Drexel, Barrell & Co.

February 23, 2026

**RE: Comment Response Letter 1 for
Willow Springs Ranch West Annexation
Lots 1 & 2 Ward Subdivision, EPC Tax Schedule #71270-01-014**

WILLOW SPRINGS ANNEXATION No. 3
CONCEPT PLAN

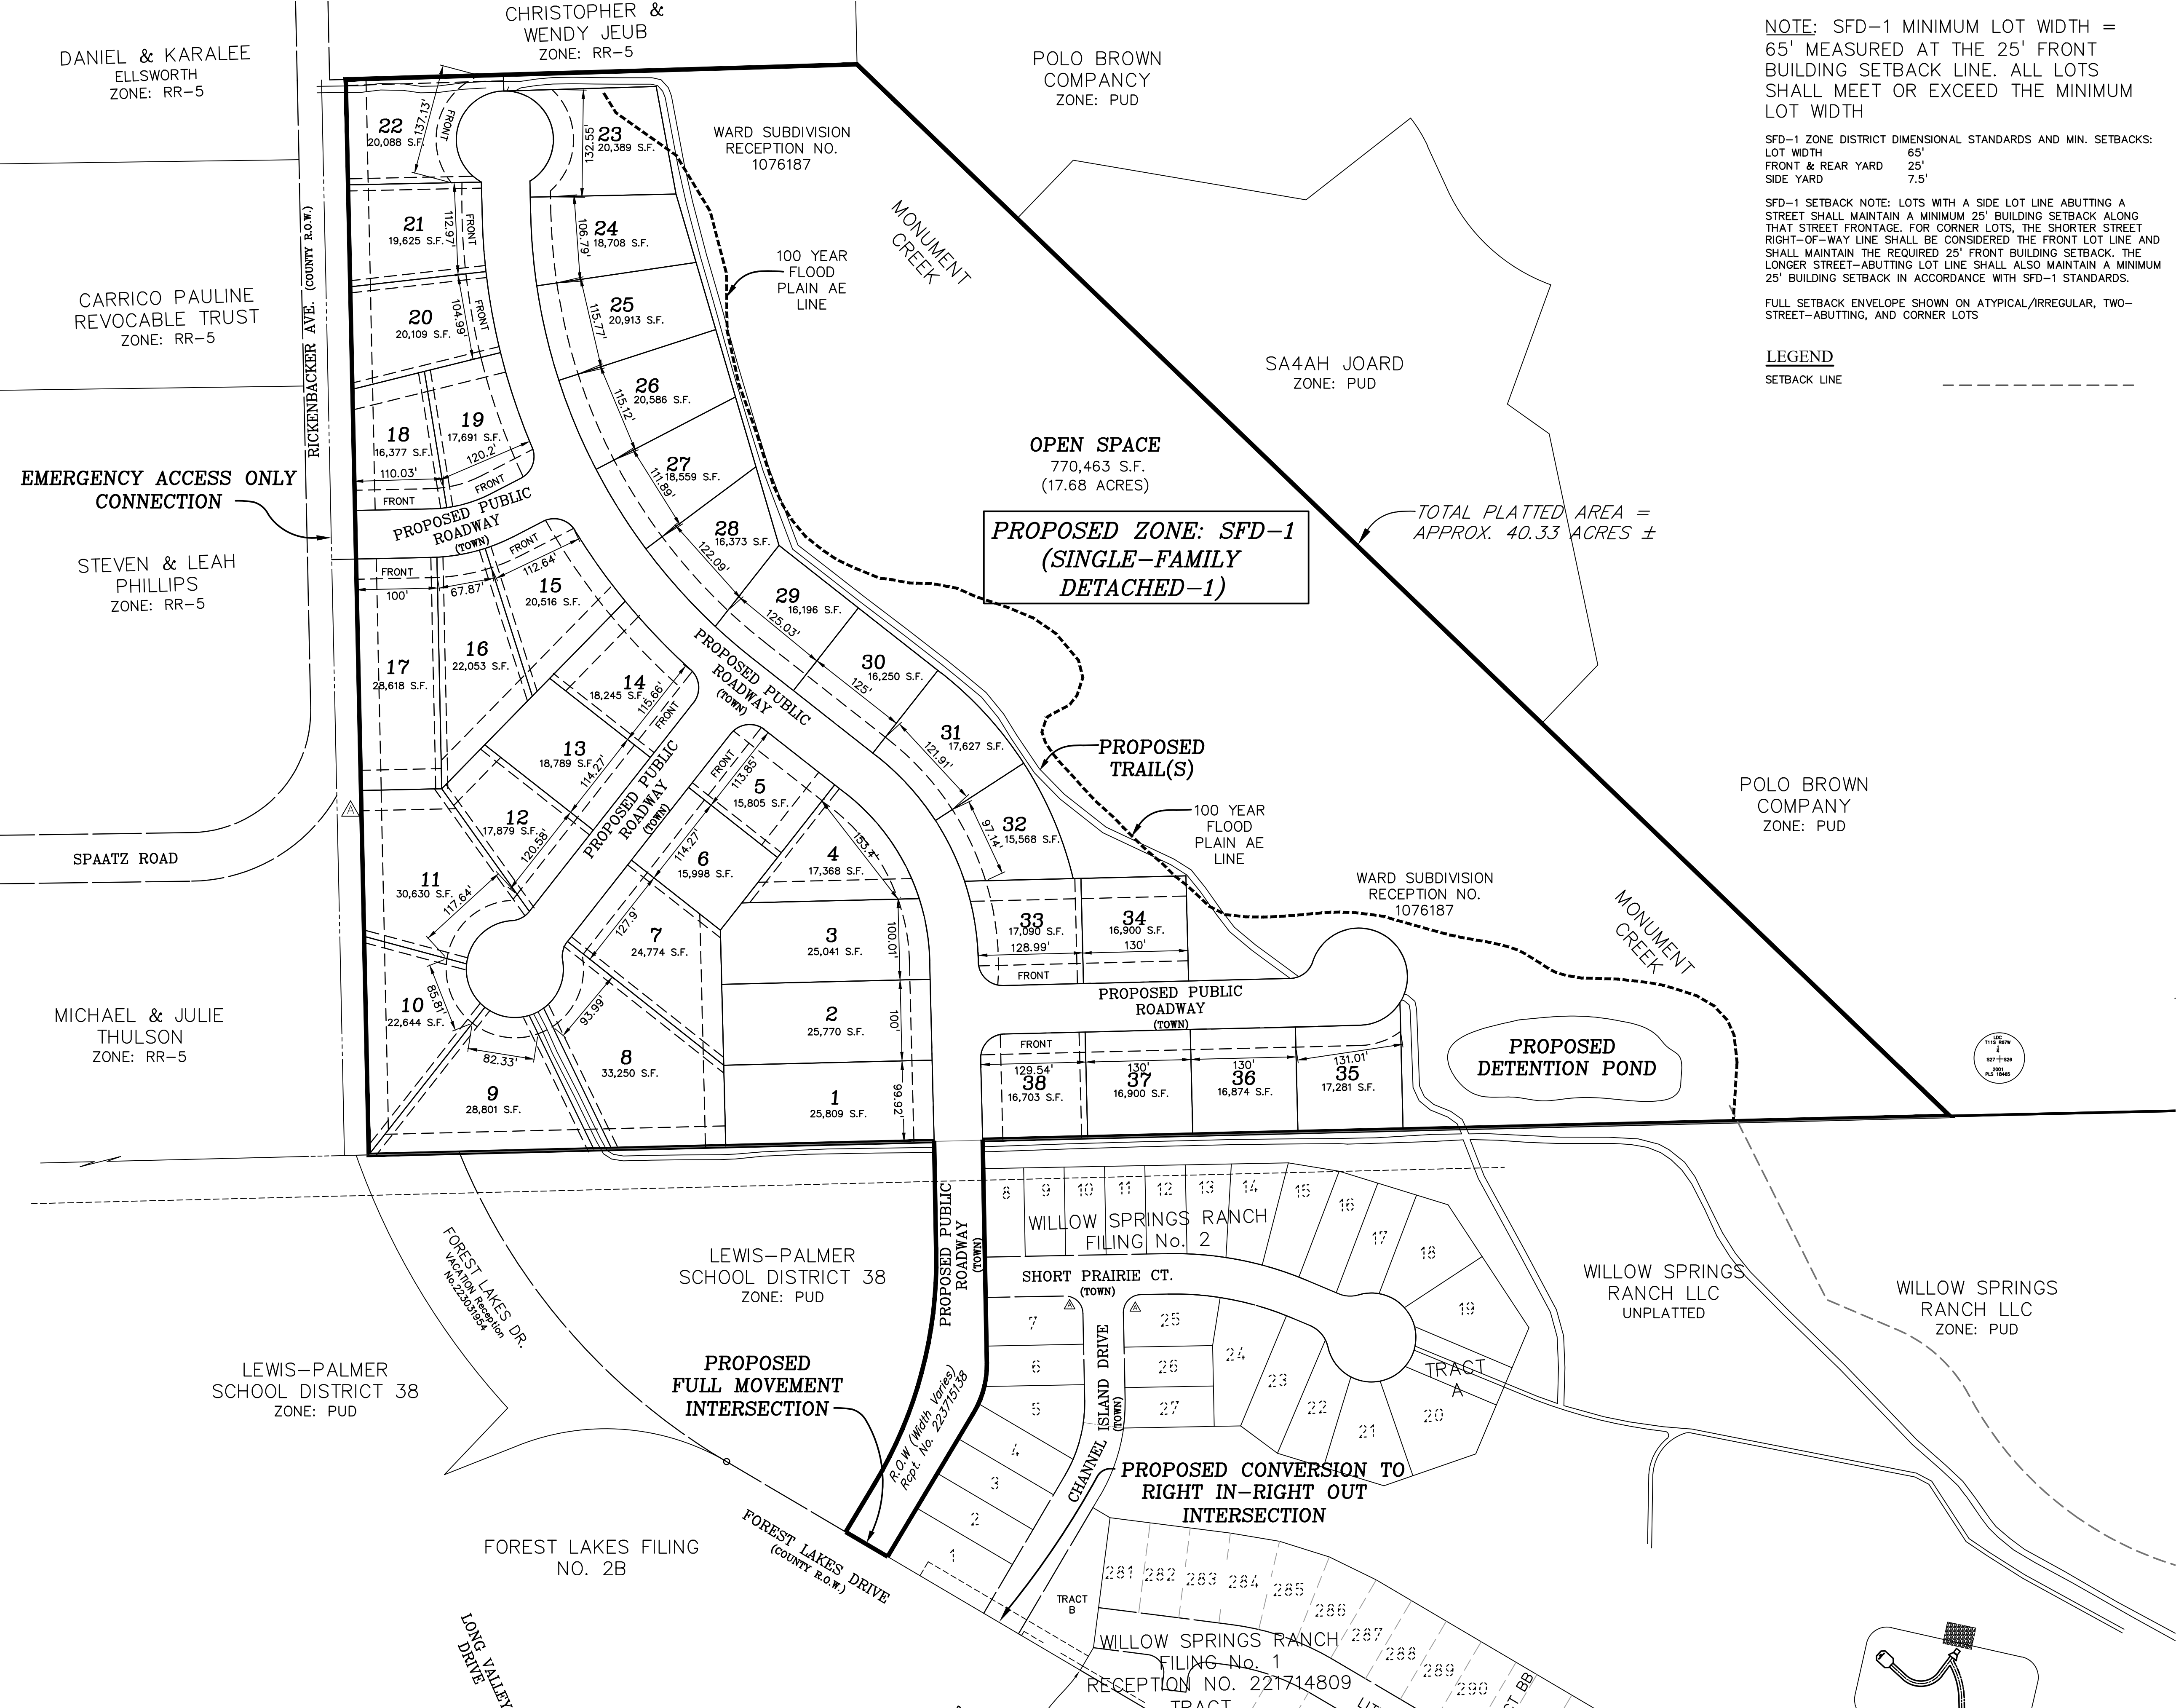
The application proposes that the site will connect to Town of Monument water via a connection at Willow Springs Ranch Filing 2. The proposed connection point has not been indicated in the submitted information.

- c. Points of proposed connection for water and wastewater must be provided on the Conceptual Land Use Plan.

Proposed water connection point and loop included, see Conceptual Land Use Plan.

Proposed connections for water and wastewater provided on Conceptual Land Use Plan.

WILLOW SPRINGS ANNEXATION No. 3

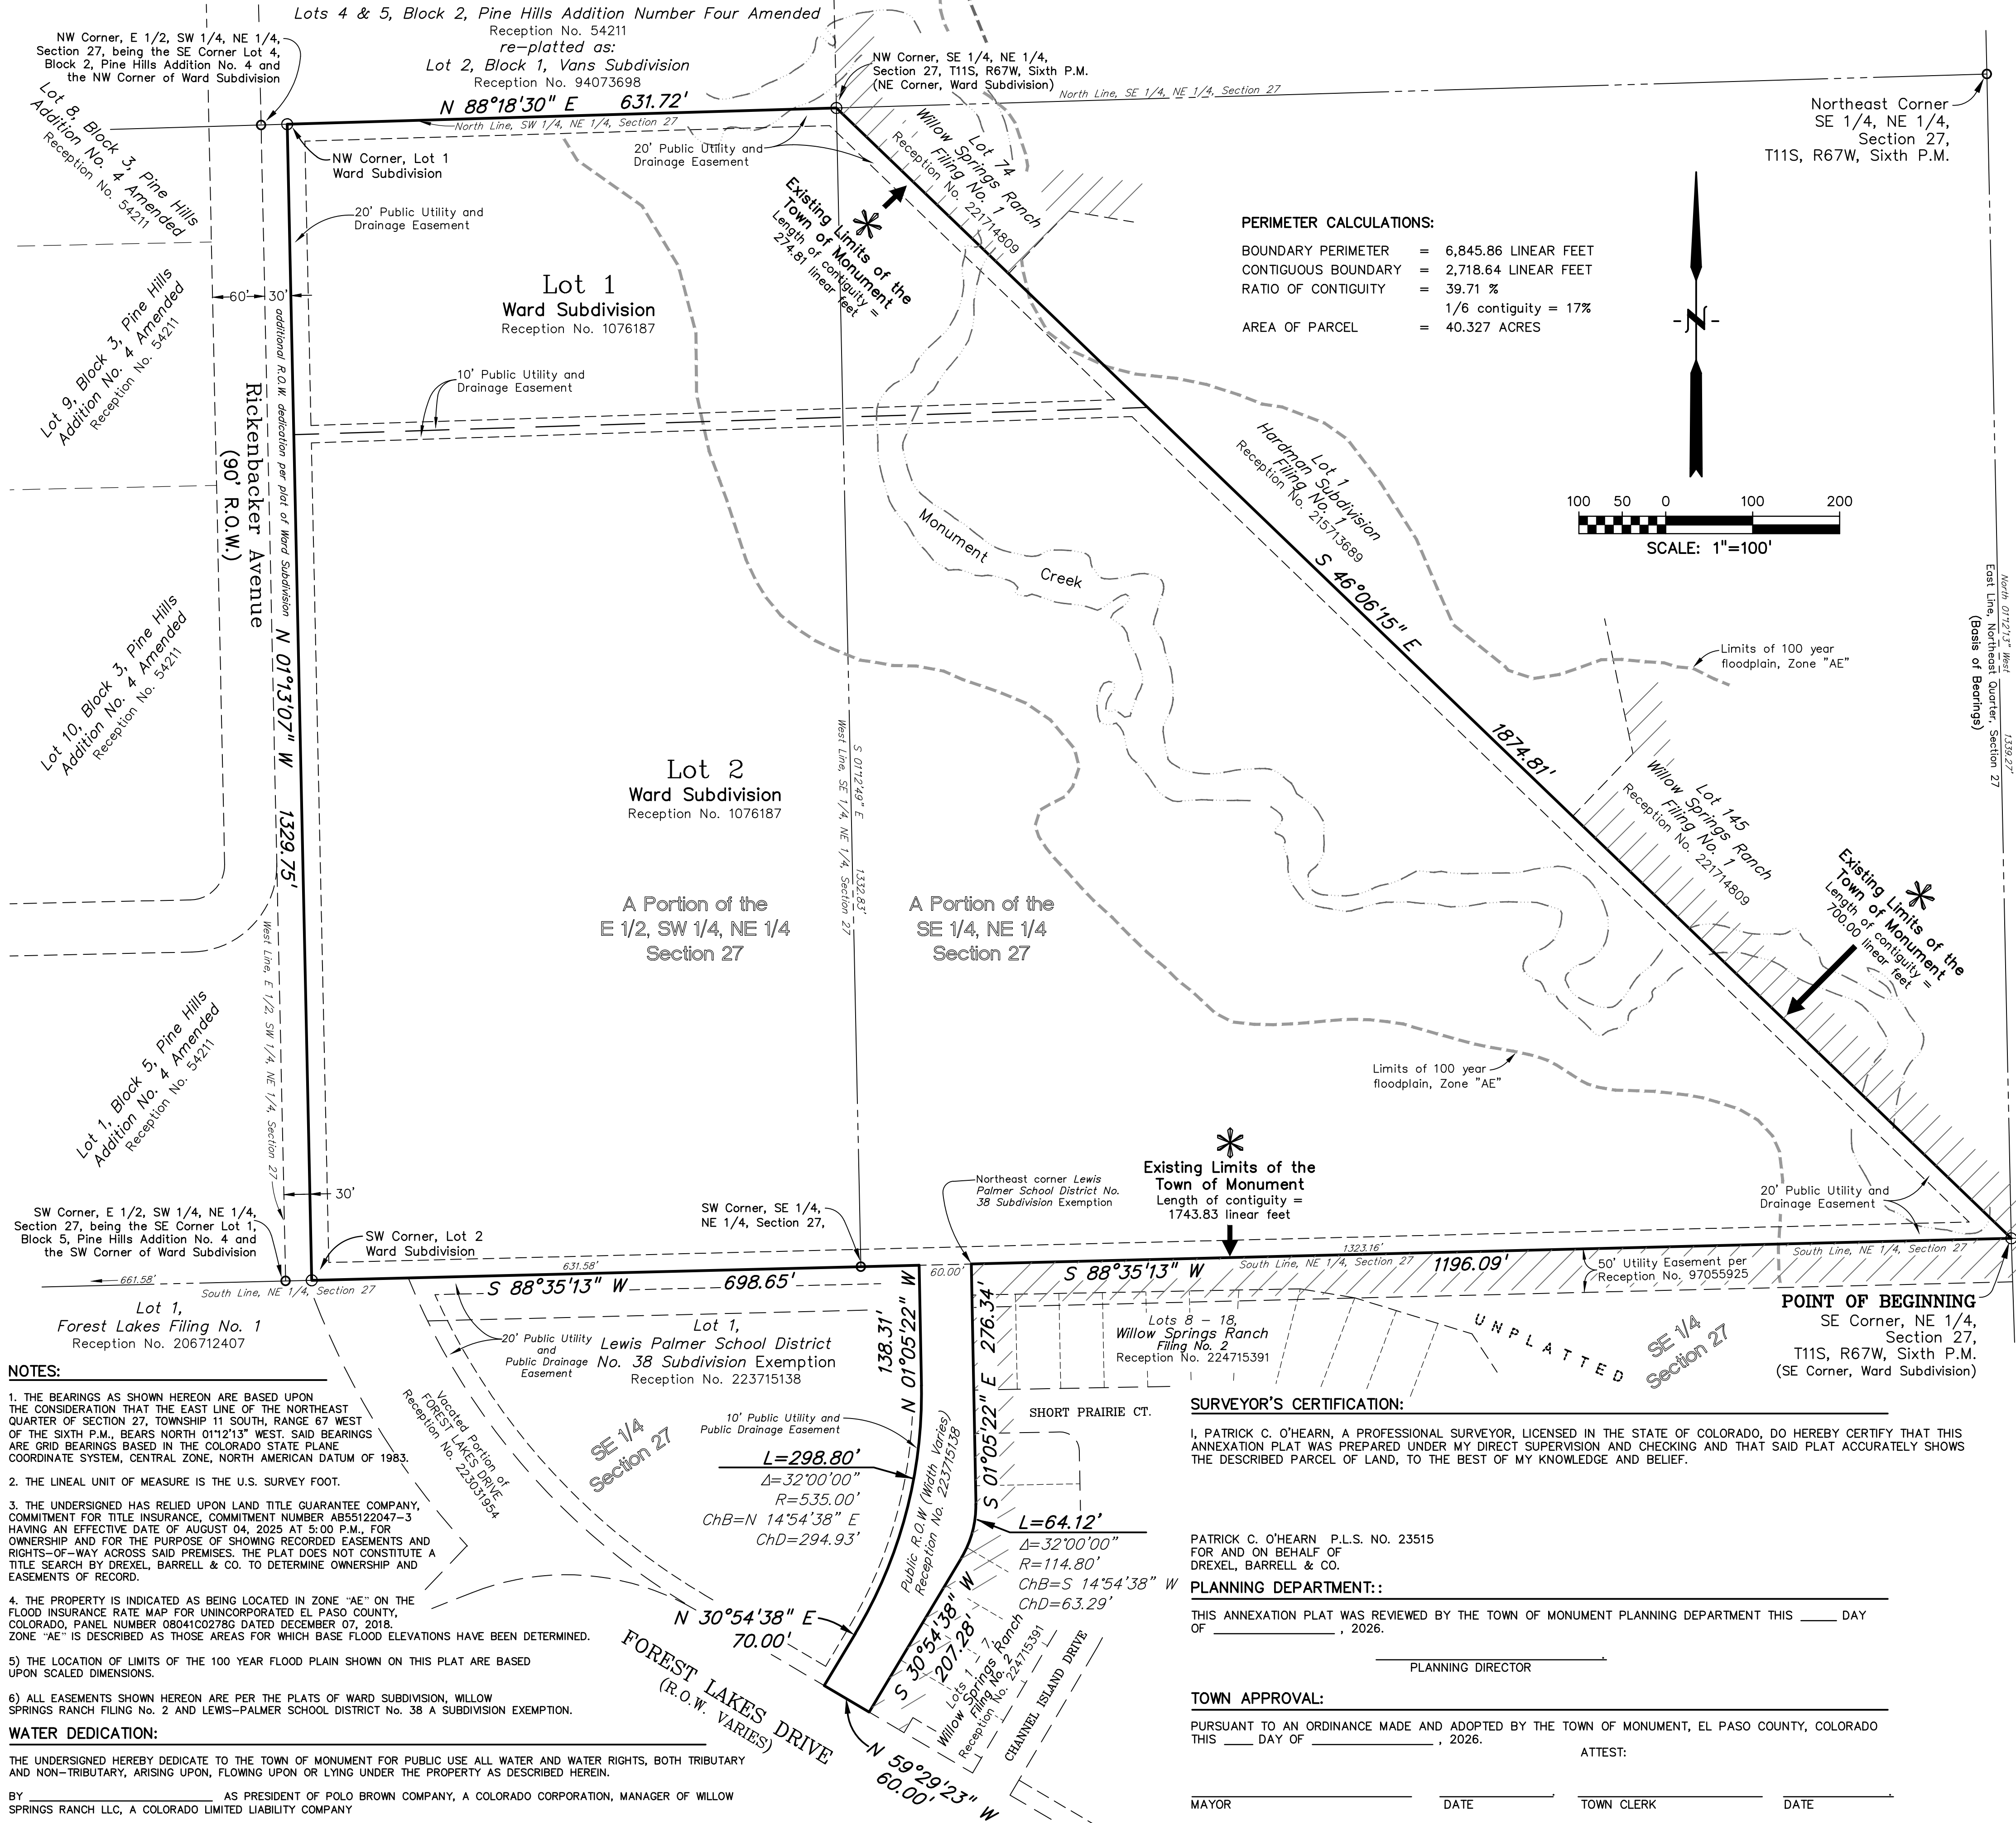
- f. Correct the name of Willow Springs Ranch Filing No. 2 on Sheet 1, there appears to be a typo.
Willow Springs Ranch Filing No. 2 corrected on page 1 of Annexation Impact Report.
- g. The reference to the public right-of-way on the west side of Willow Springs Ranch Filing No. 2 needs to be made darker in order to be visible.

Reference to public right-of-way on west side of Willow Springs Ranch Filing No. 2 corrected (darker/more visible).
